May 13, 2016

Re: Taco Bell Renovations

4815 4th St NW

Request for Permanent C.O. - Accepted Engineer's Stamp dated: 8-26-15 (F14D071)

TCL-1

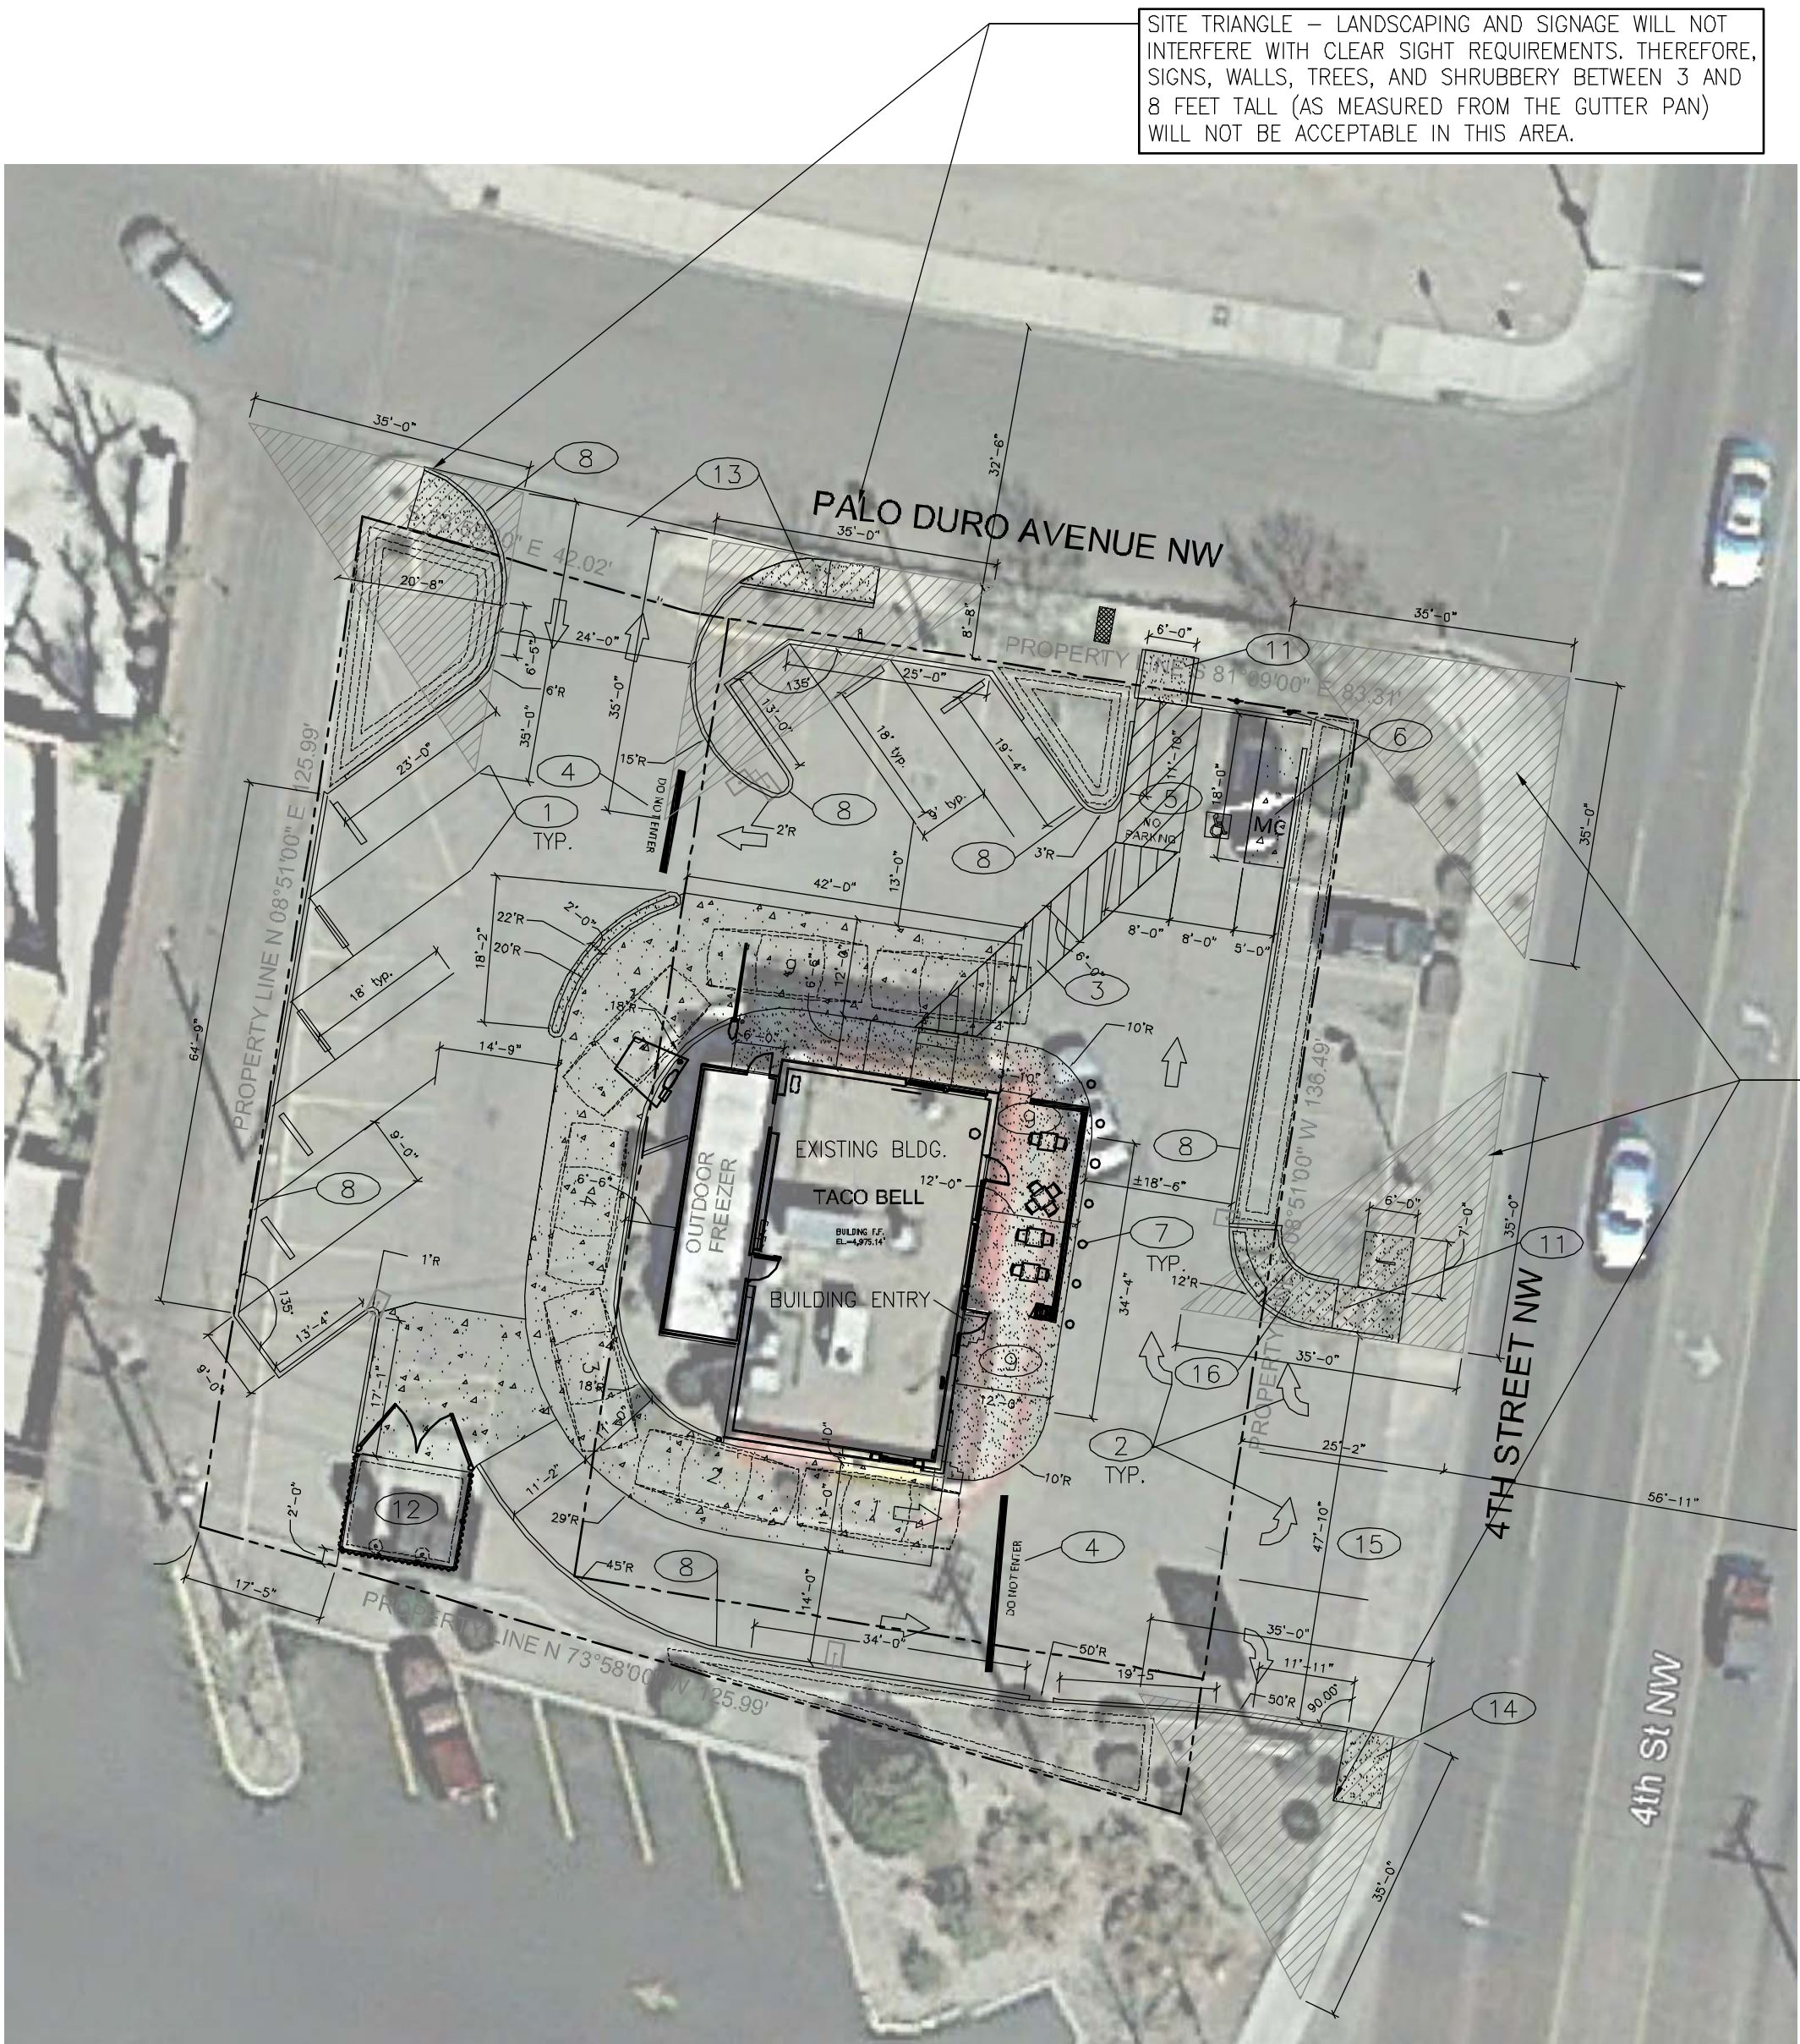
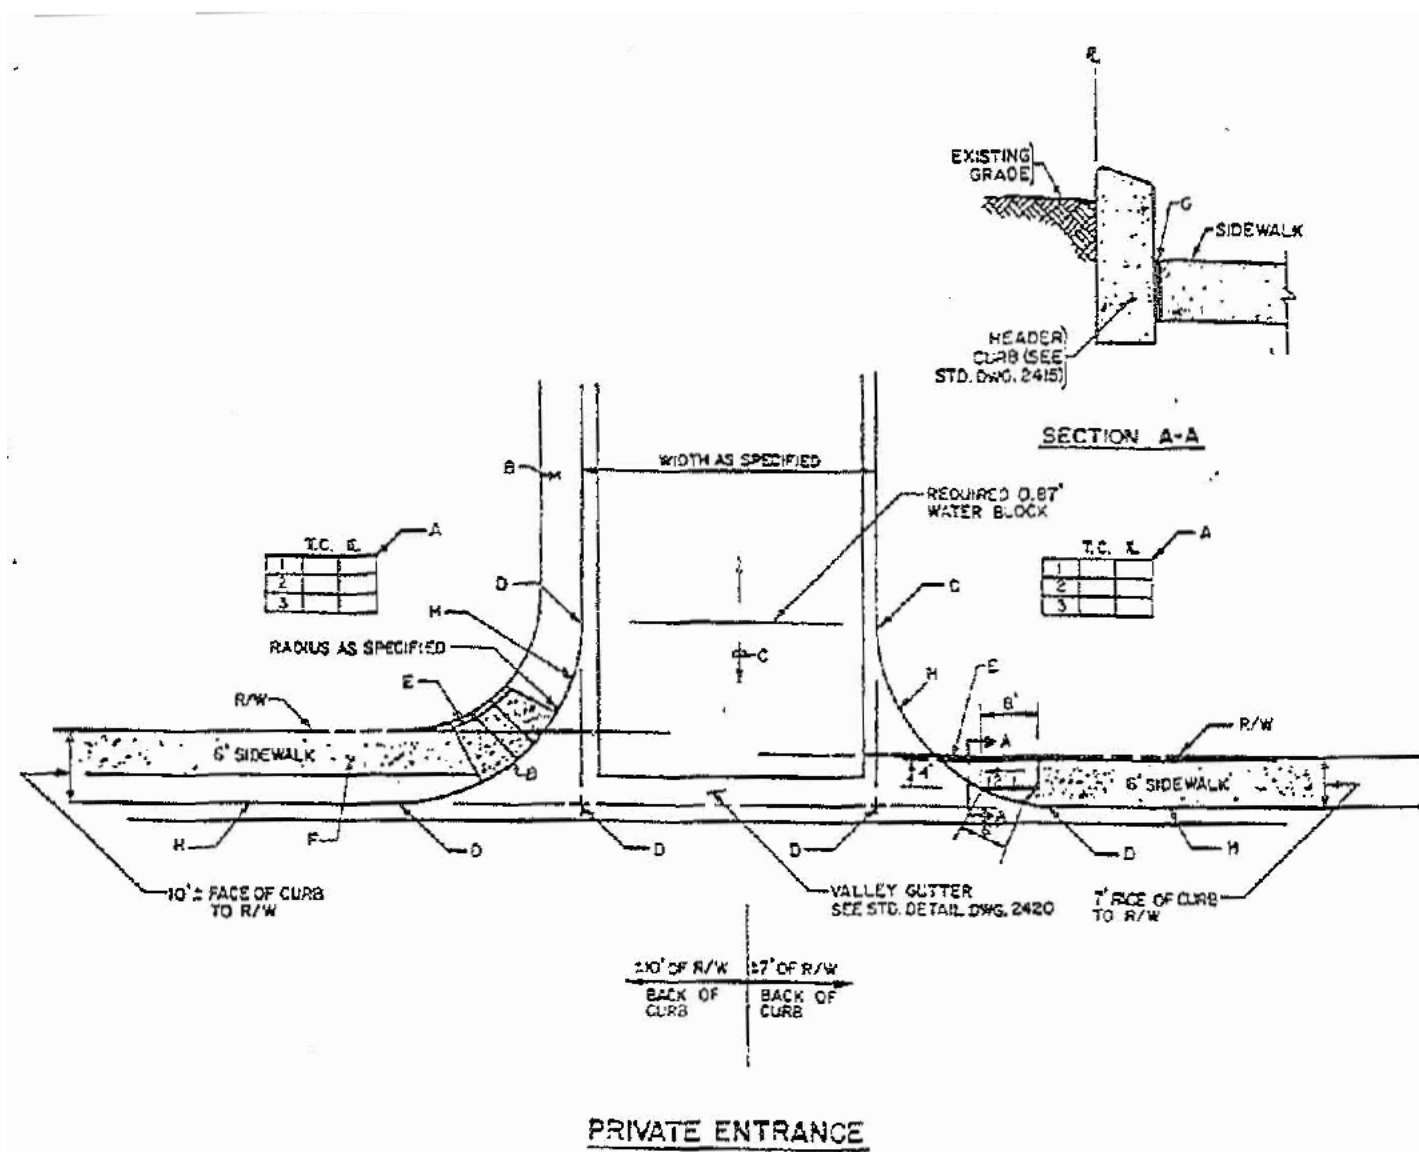
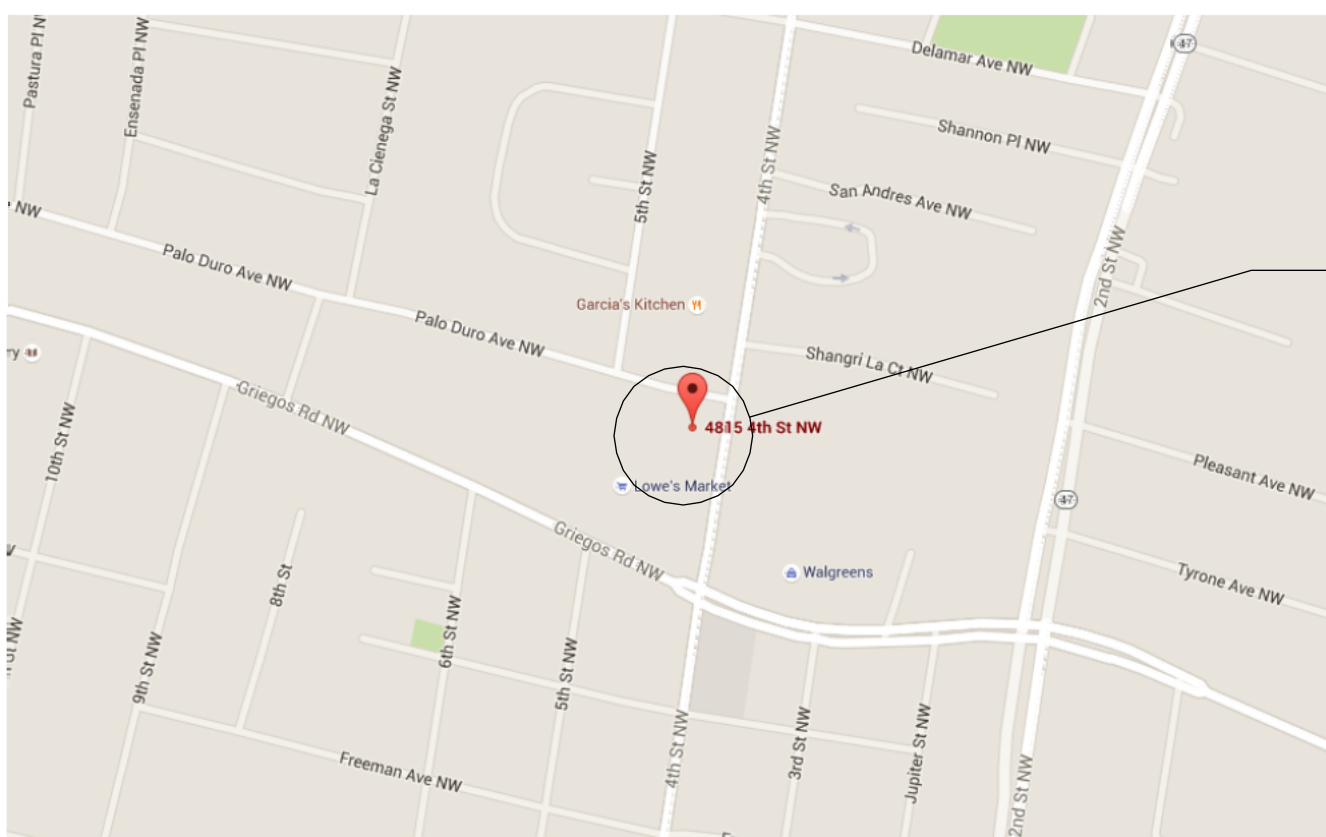
1. Please detail sidewalk and drive pad ramps on Palo Duro Ave. and 4th St. per COA City Standard specifications. ADA truncated domes need to be called out at all ramps where pedestrians cross onto traffic lanes.

2. Please provide a sight distance exhibit (see the *Development Process Manual*, Chapter 23, Section 3, Part D.5 Intersection Sight Distance). Please provide this detail for drive pad entrances/exits on Palo Duro Ave. and 4th St..

- 3. Please add the following note to the clear sight triangle: "Landscaping and signage will not interfere with clear sight requirements. Therefore, signs, walls, trees, and shrubbery between 3 and 8 feet tall (as measured from the gutter pan) will not be acceptable in this area." This detail is for drive pad entrances/exits on Palo Duro Ave. and 4th St..
- 4. Please include two copies of the traffic circulation layout at the next submittal.
